Grandview Metro District Project

1041 Submission

Engineering Review

EPC Planning & Community Development Department

WELL SITE LOCATIONS

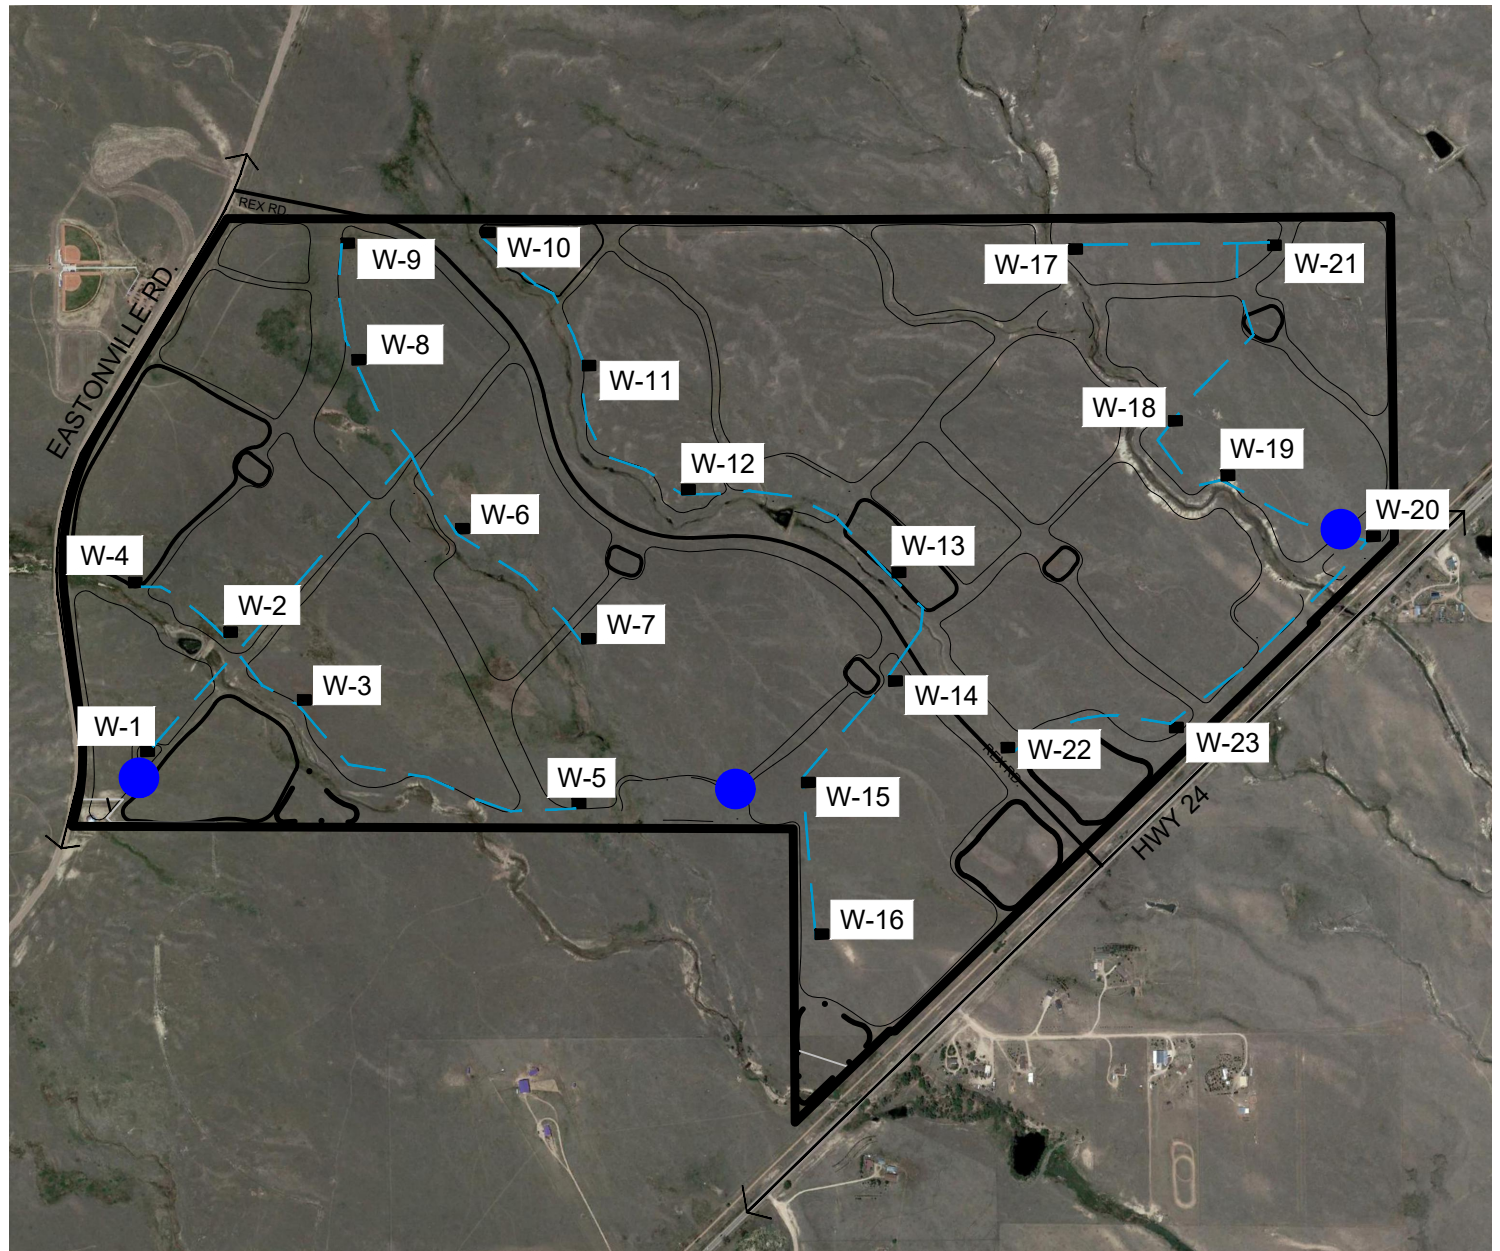
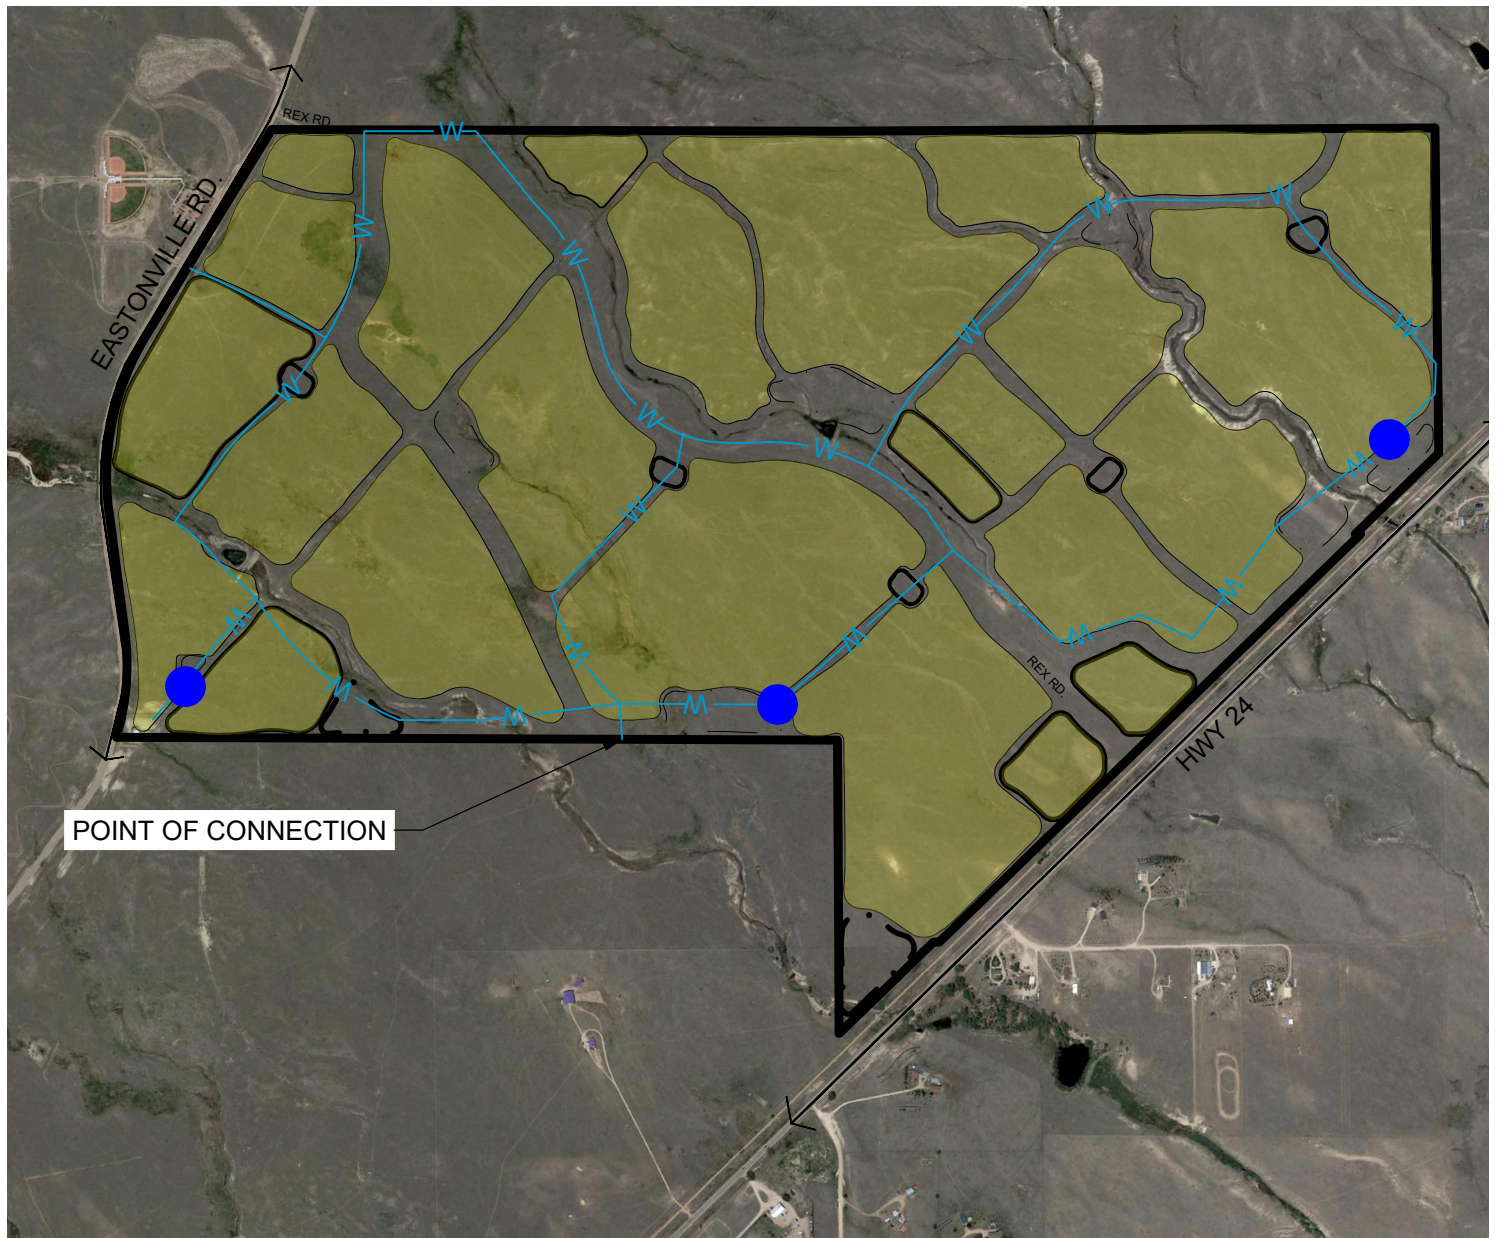
show on maps

show tank locations as well as pump houses etc on maps

PROPOSED DUAL FORCE MAINS

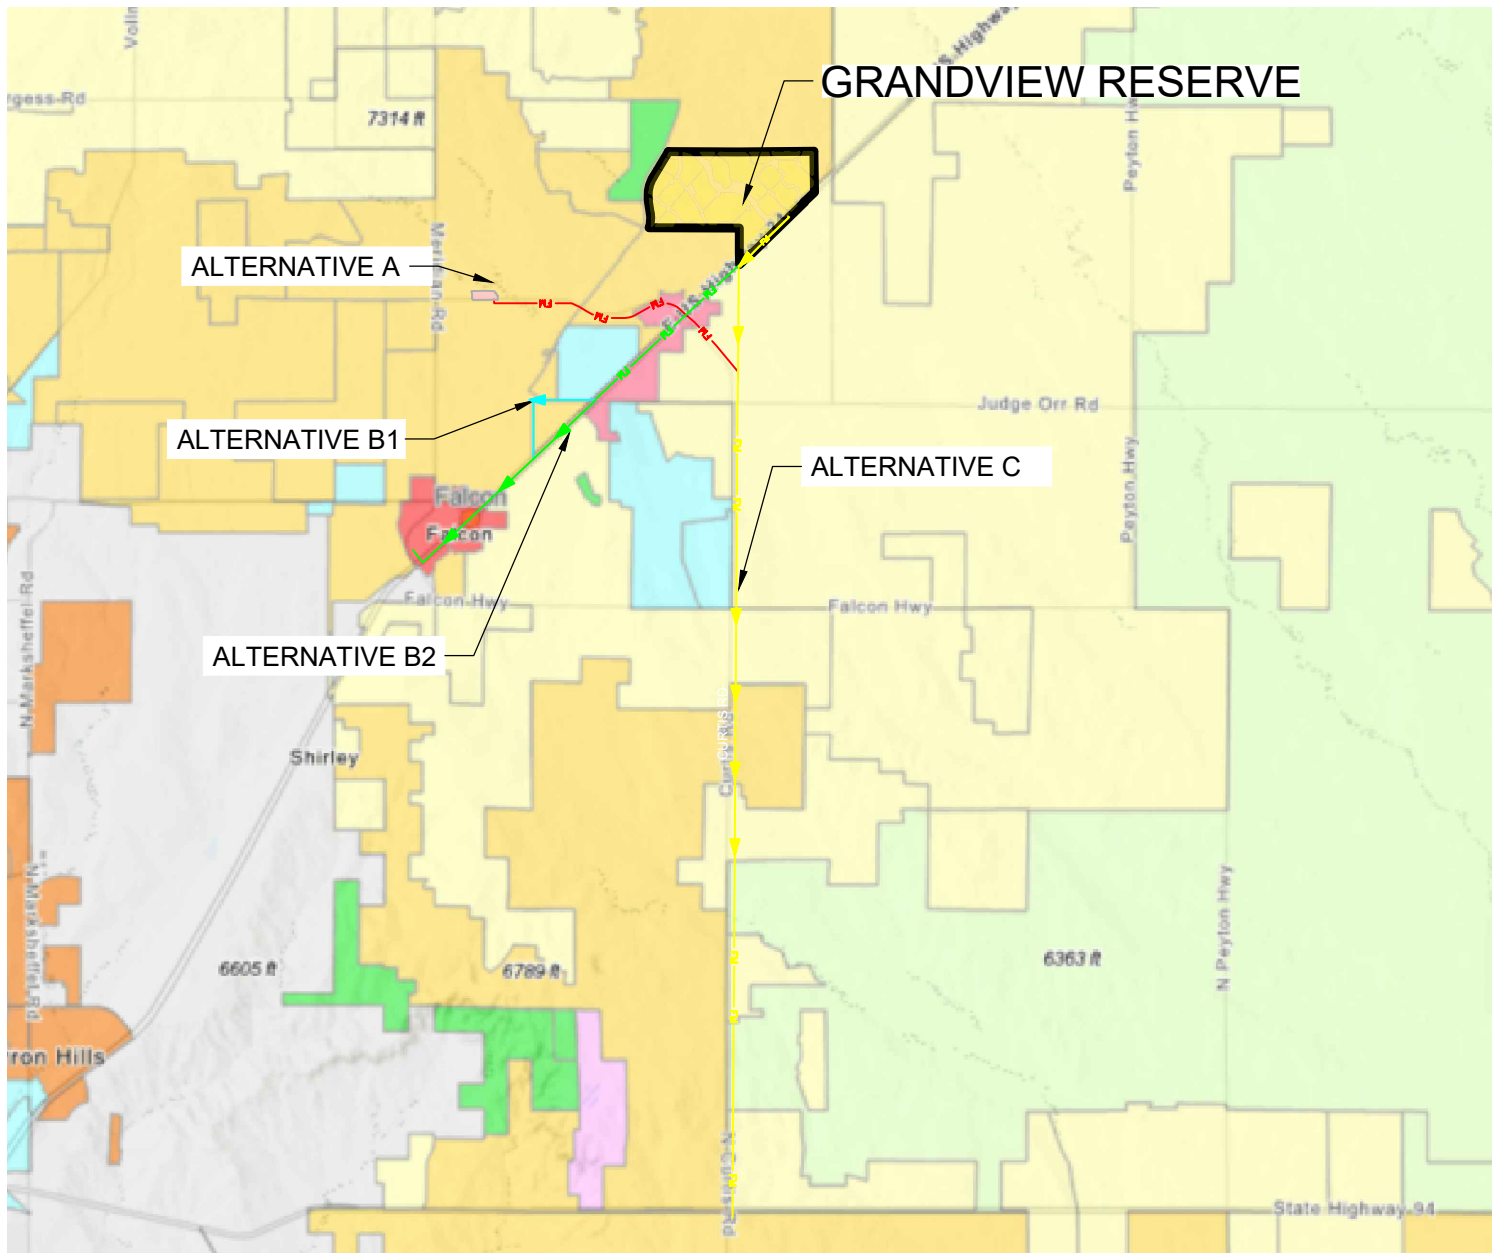
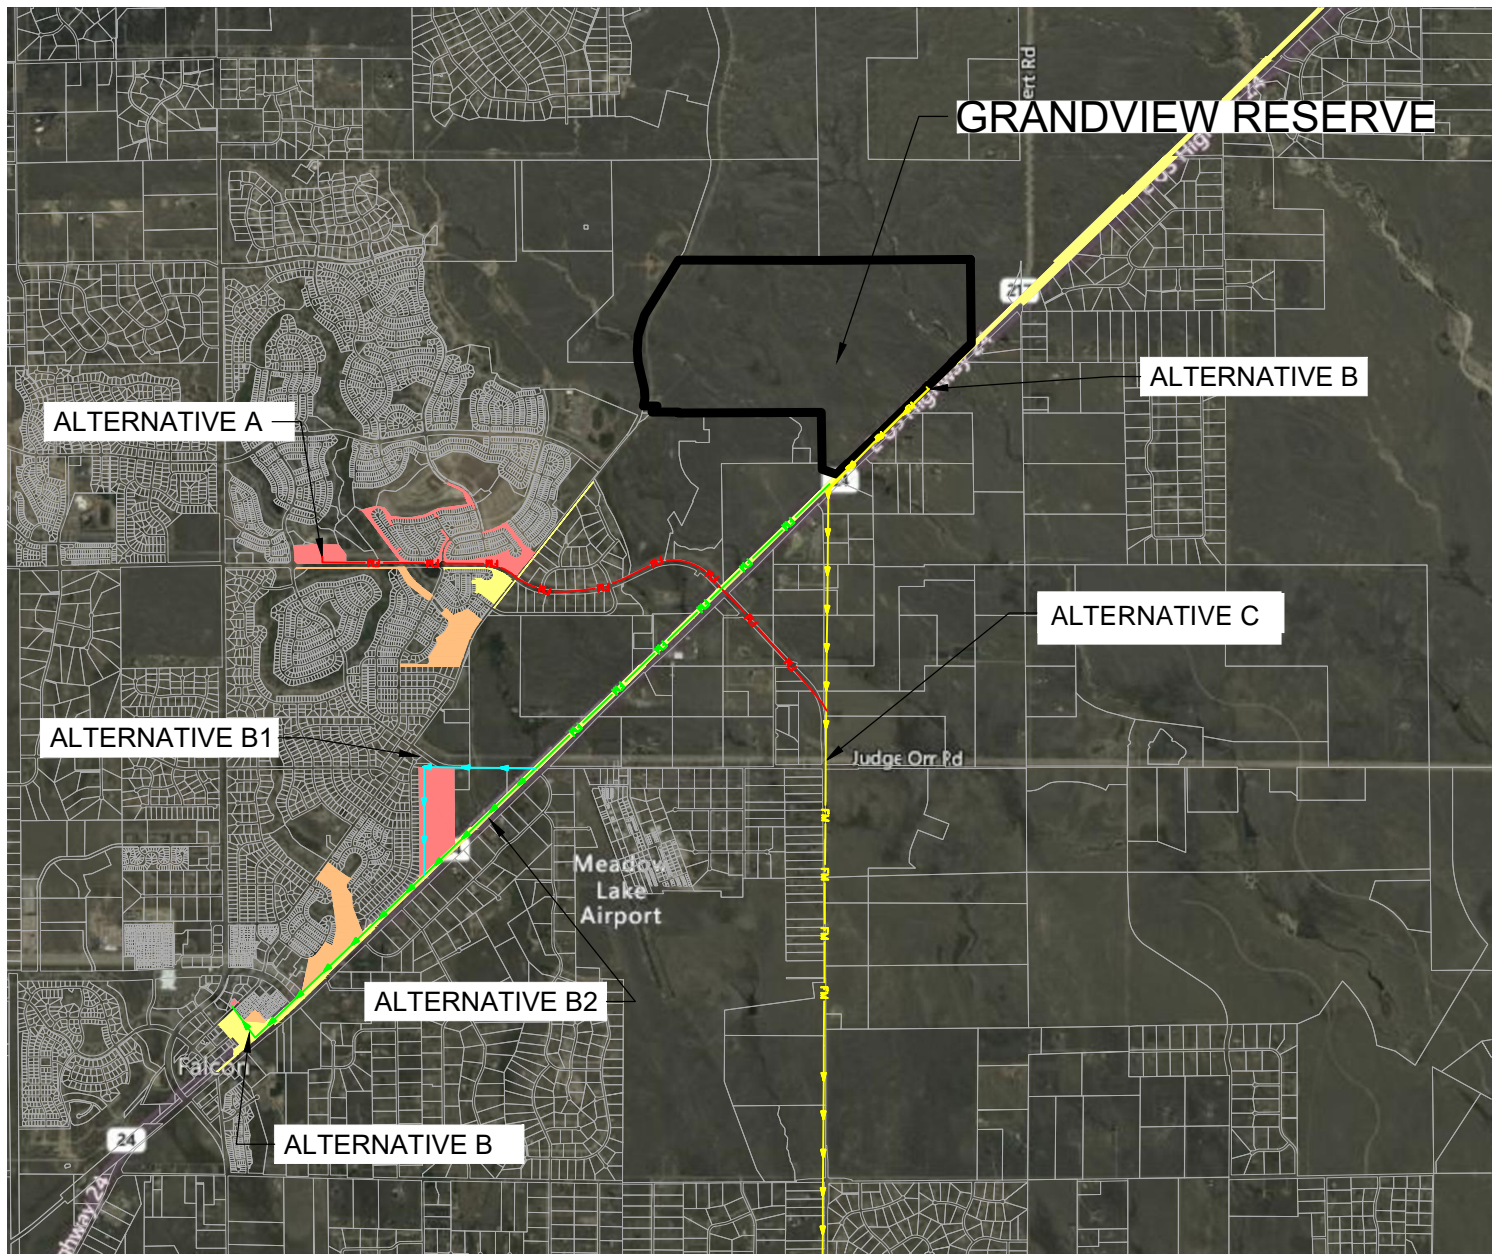
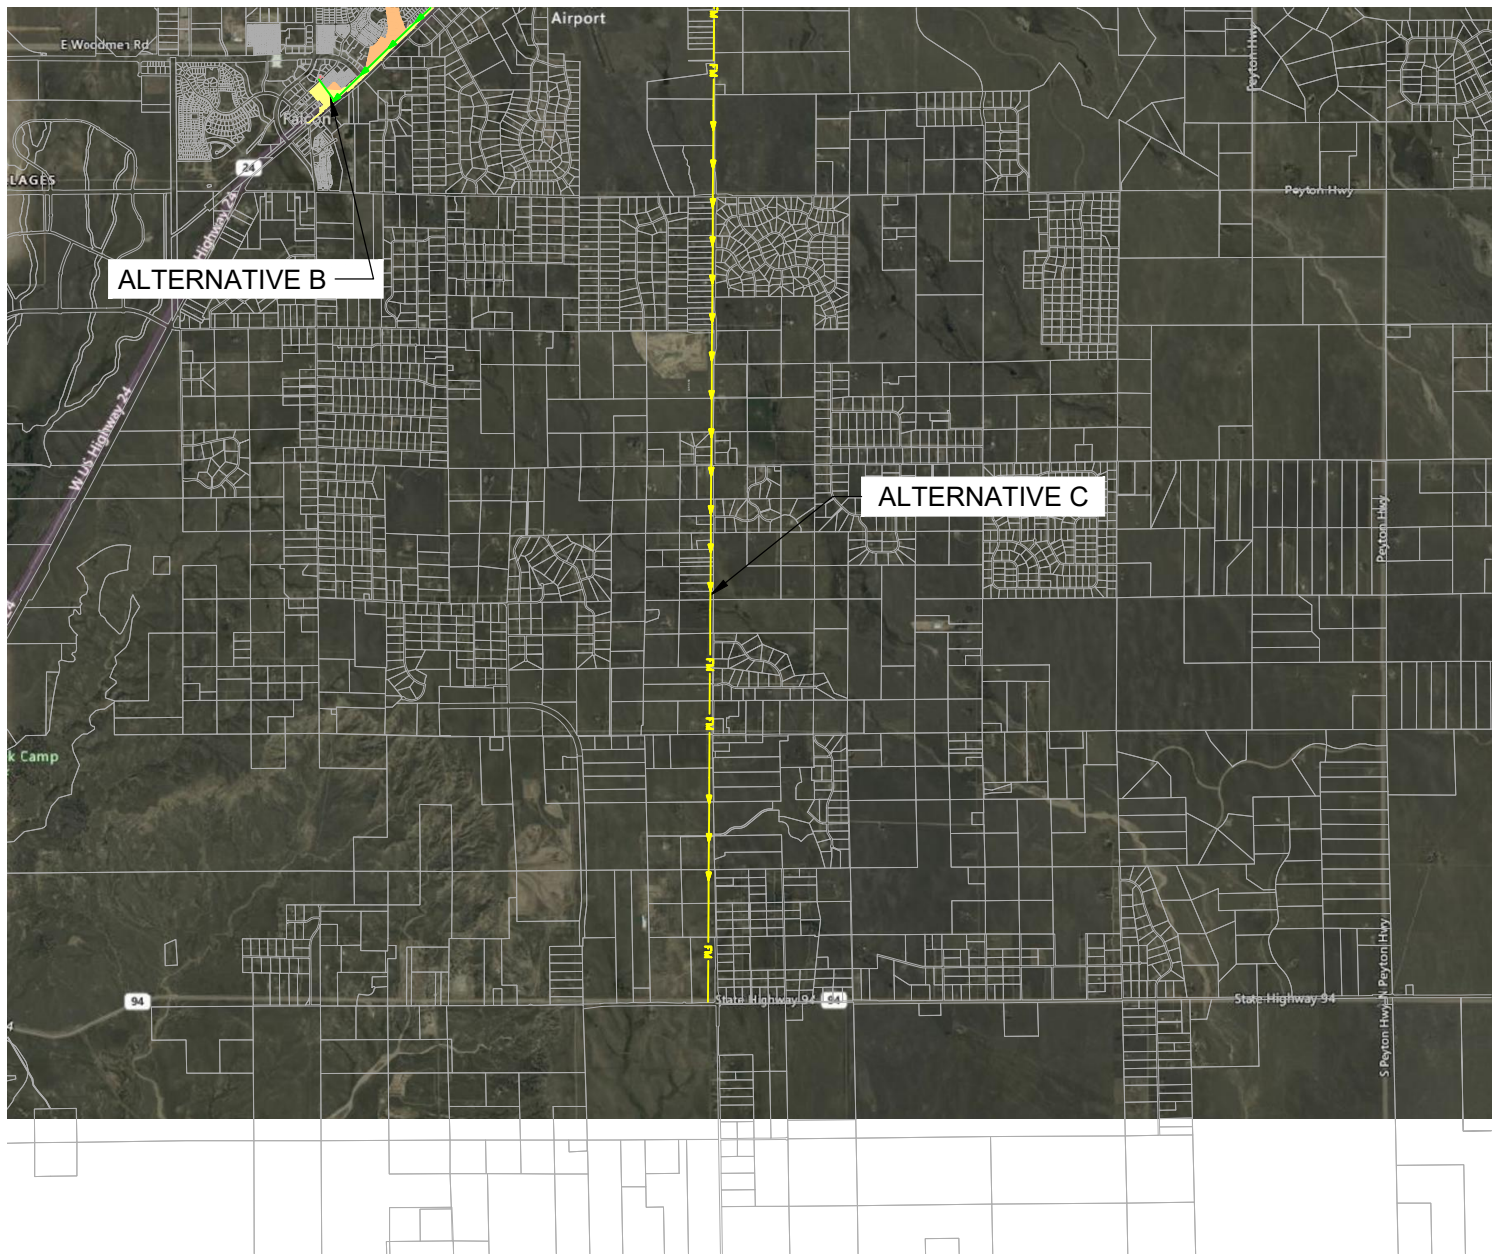
Please depict the expansion Cherokee MD will have to do to serve this development so that Cherokee MD does not have to do a separate 1041 which will delay your development because to build out

Grand-view; Cherokee has to expand a treatment facility and possibly add a lift station. Show this on the map, and include in text. This 1041 is for the siting of the whole sketch plan area not just the first PUD. IF YOU do NOT, when you go to second phase you may be delayed until CMD obtains the approvals for their expansion which is necessary to handler the wastewater flows from Grandview. Use options on maps if you do not have details.

two parallel - how many miles

All of this infrastructure shall be mapped on the water and Sewer maps (include alternatives so we dont need to amend the 1041 later)
